# DRB CASE ACTION LOG (PREL & FINAL)

DRB Application No.: 04DRB-01665 (P&F)

Project Name NO. ALBUQ. ACRES UNIT B

D.R.B. CASE NO.: 1003372 DATE: 11/3/04 ITEM NO.: 11

**CONCEPTUAL
GRADING & UTILITY
PLAN**

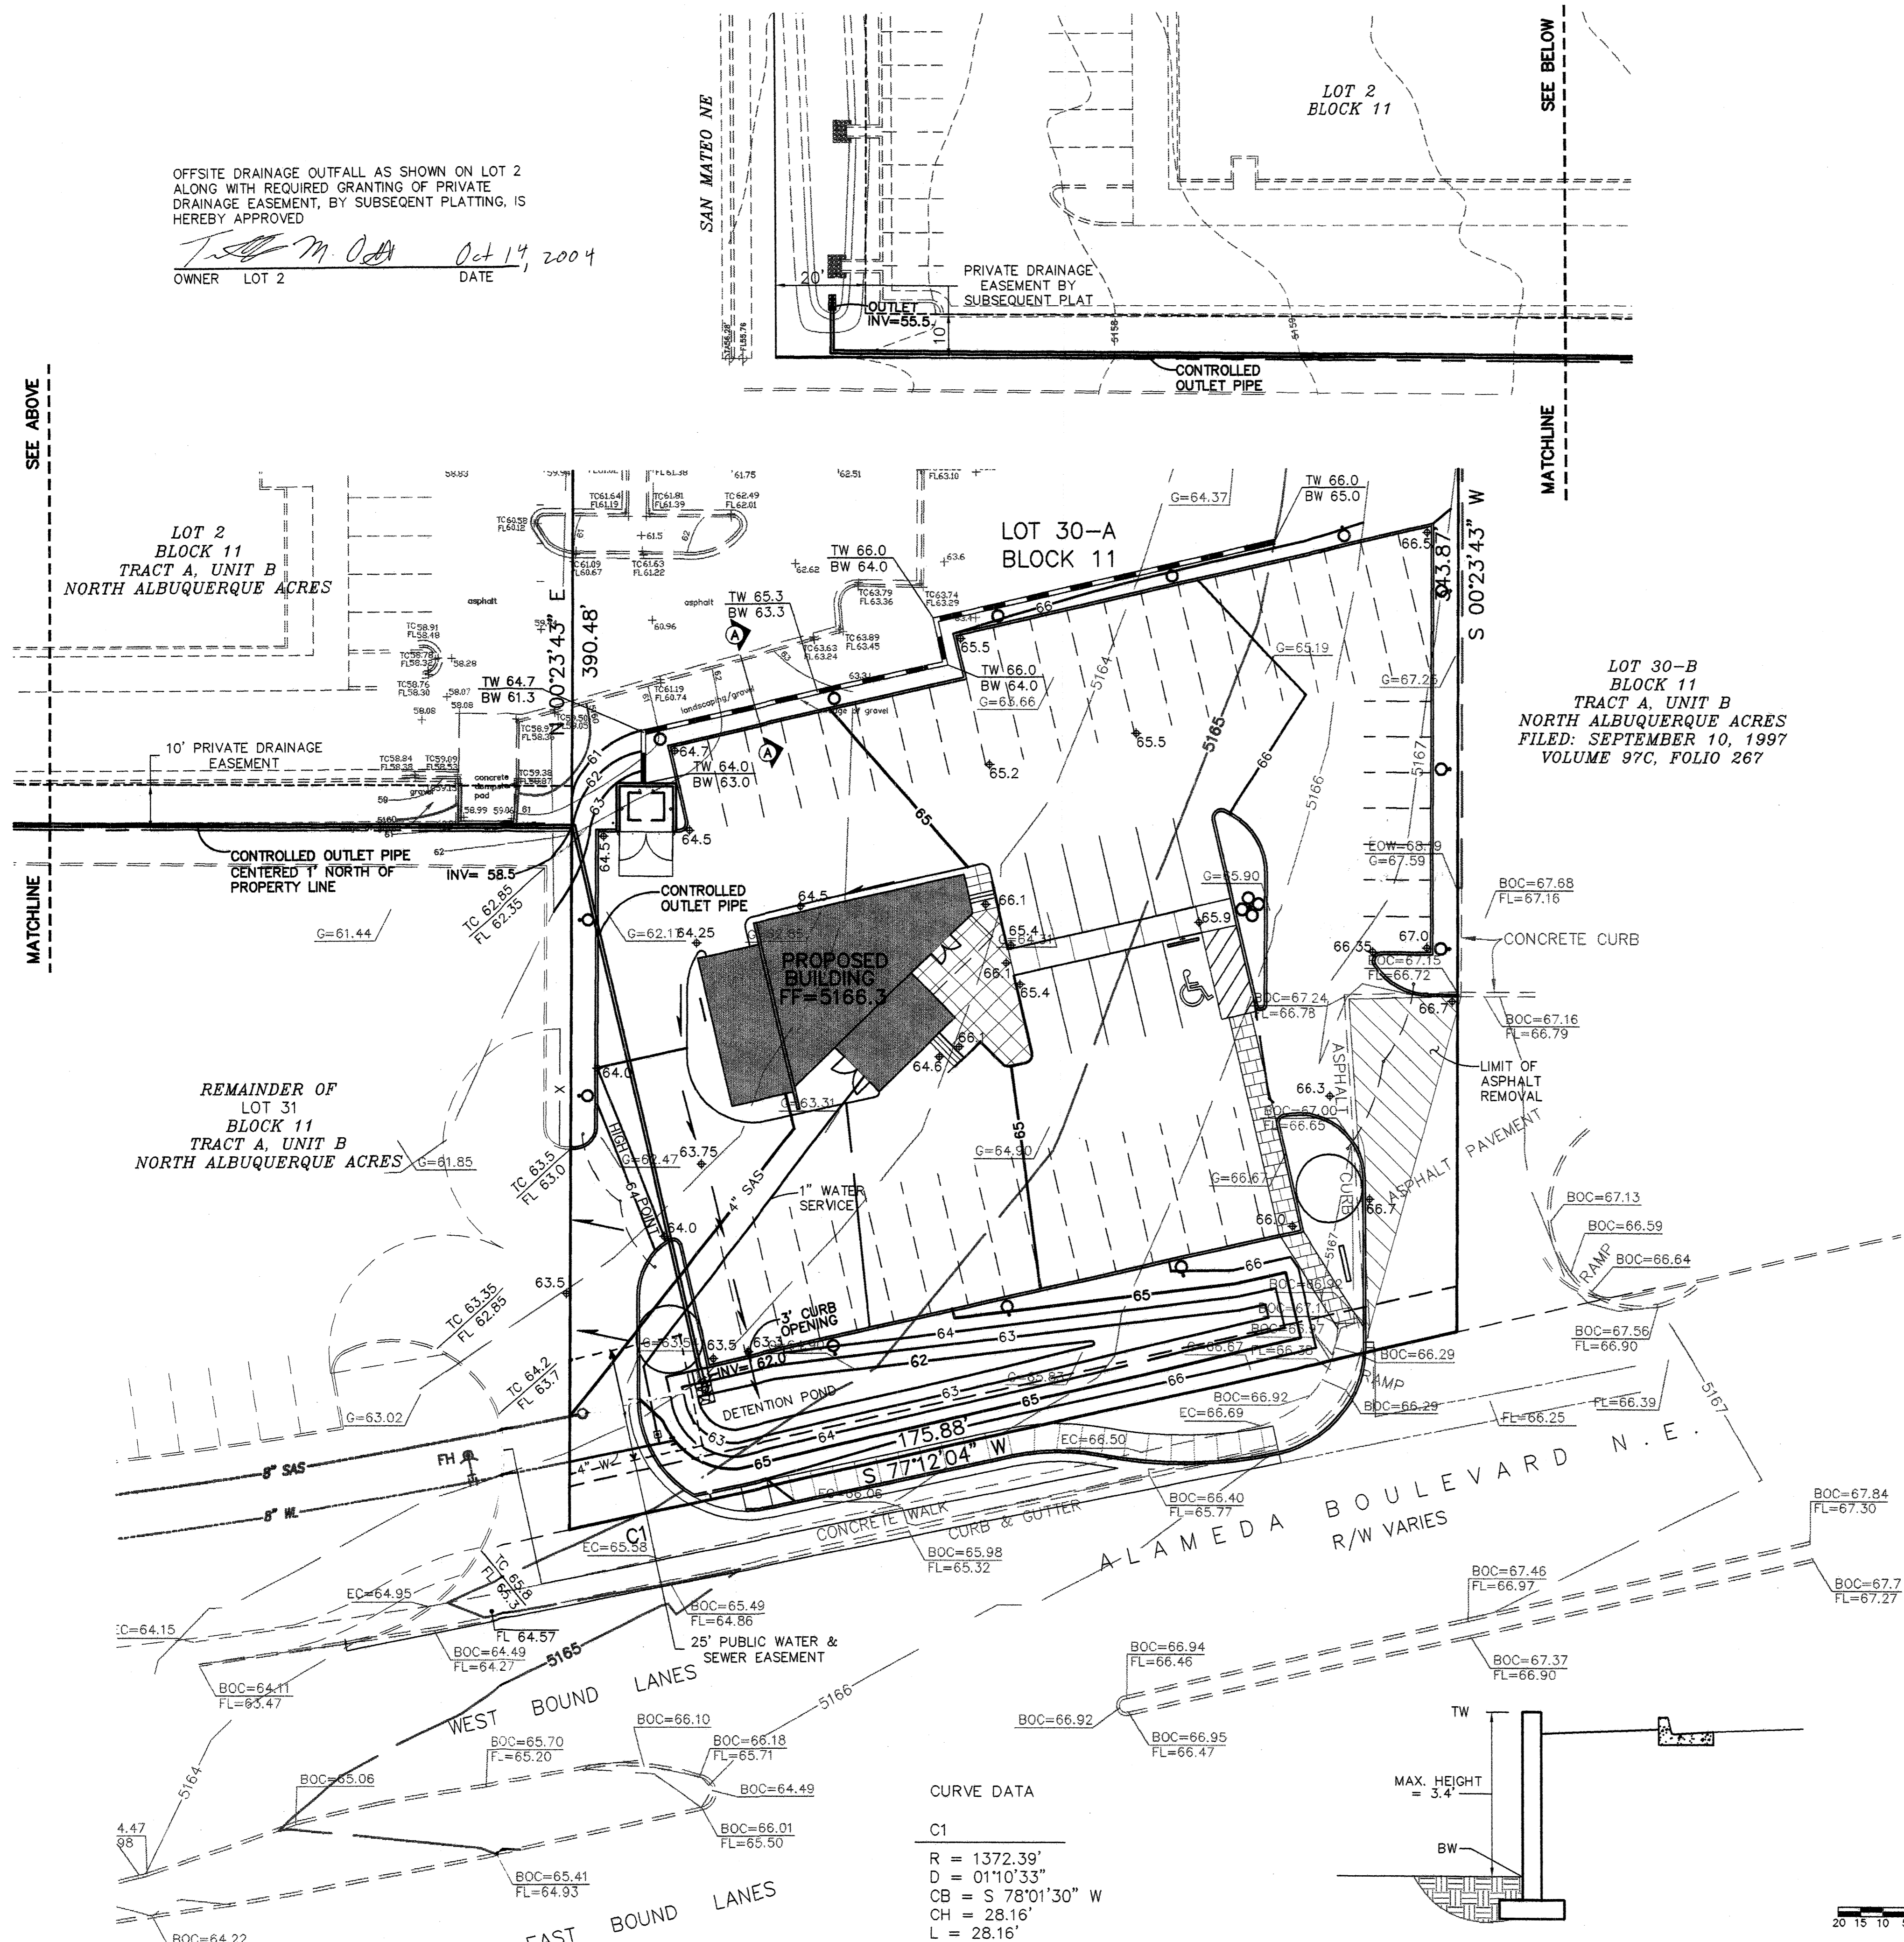
1.) Can't tell if the SAS MH shown @ the SW corner of site is existing. This MH is public + must be within the new public water + SAS easement on plat, with allowance for trenching @ MH.

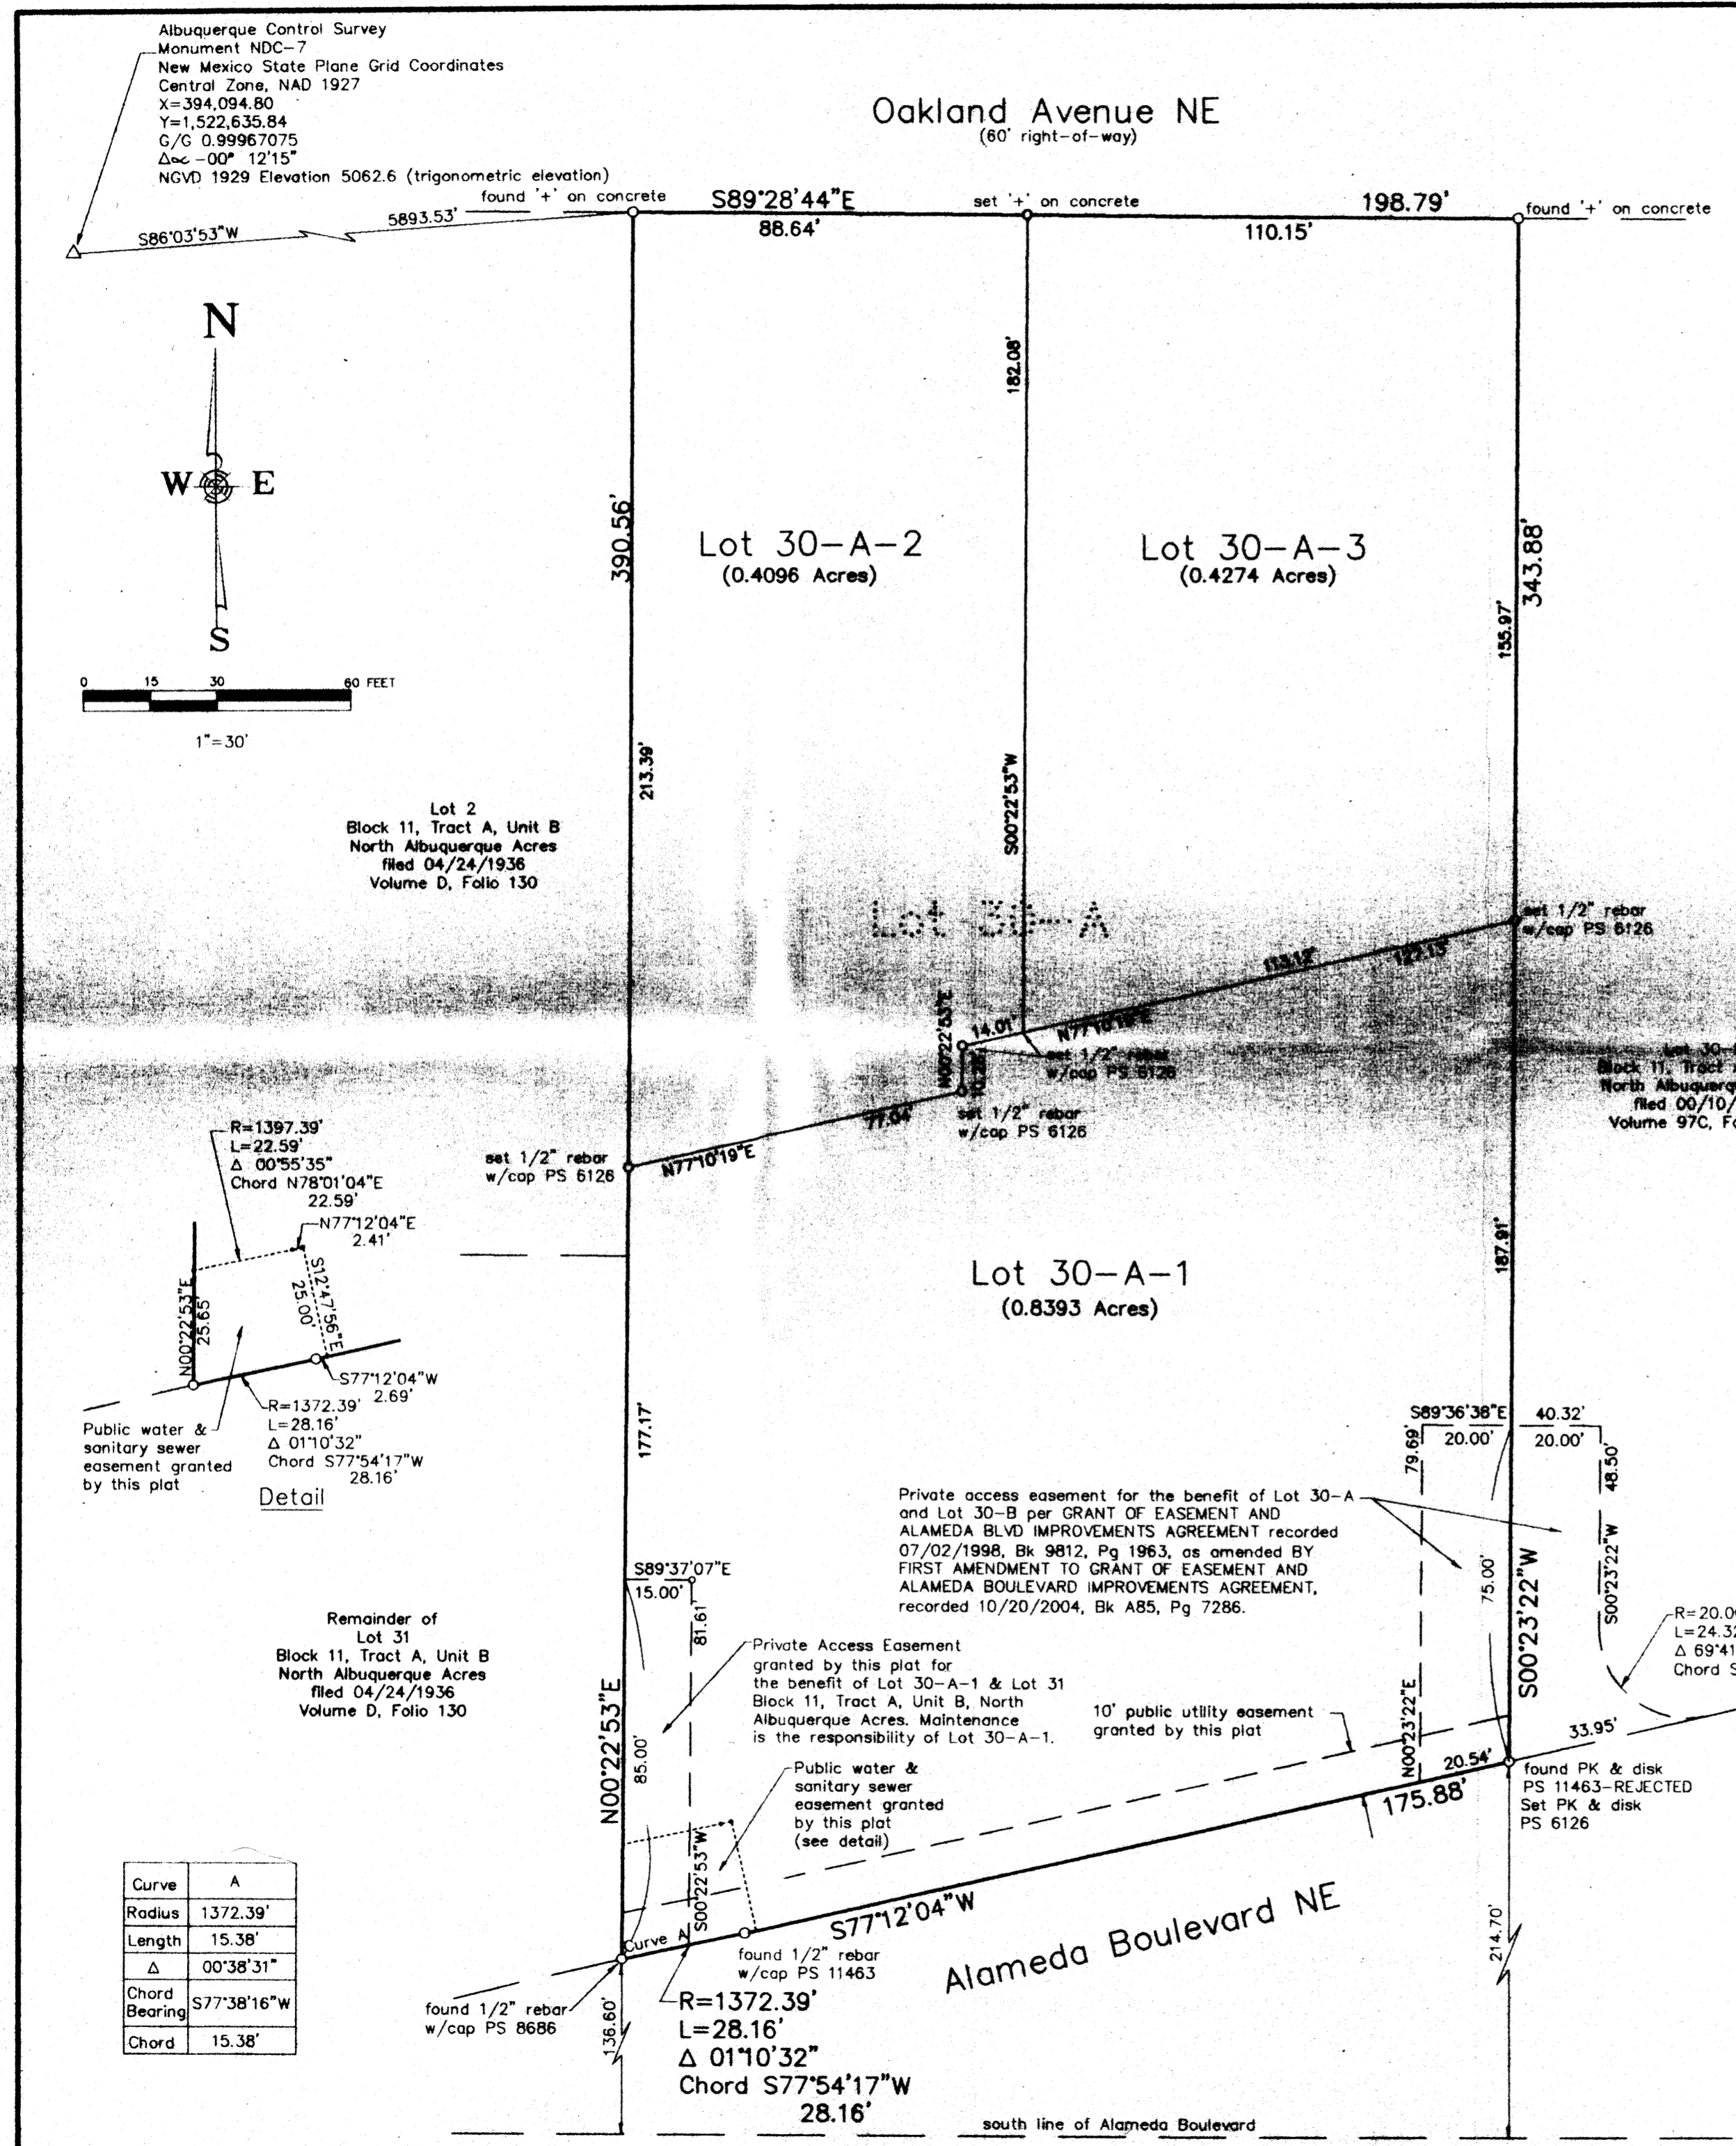
UTILITIES: \_\_\_\_\_  
 Accommodate New public SAS MH within  
 New public SAS + W easment  
 \_\_\_\_\_  
 \_\_\_\_\_
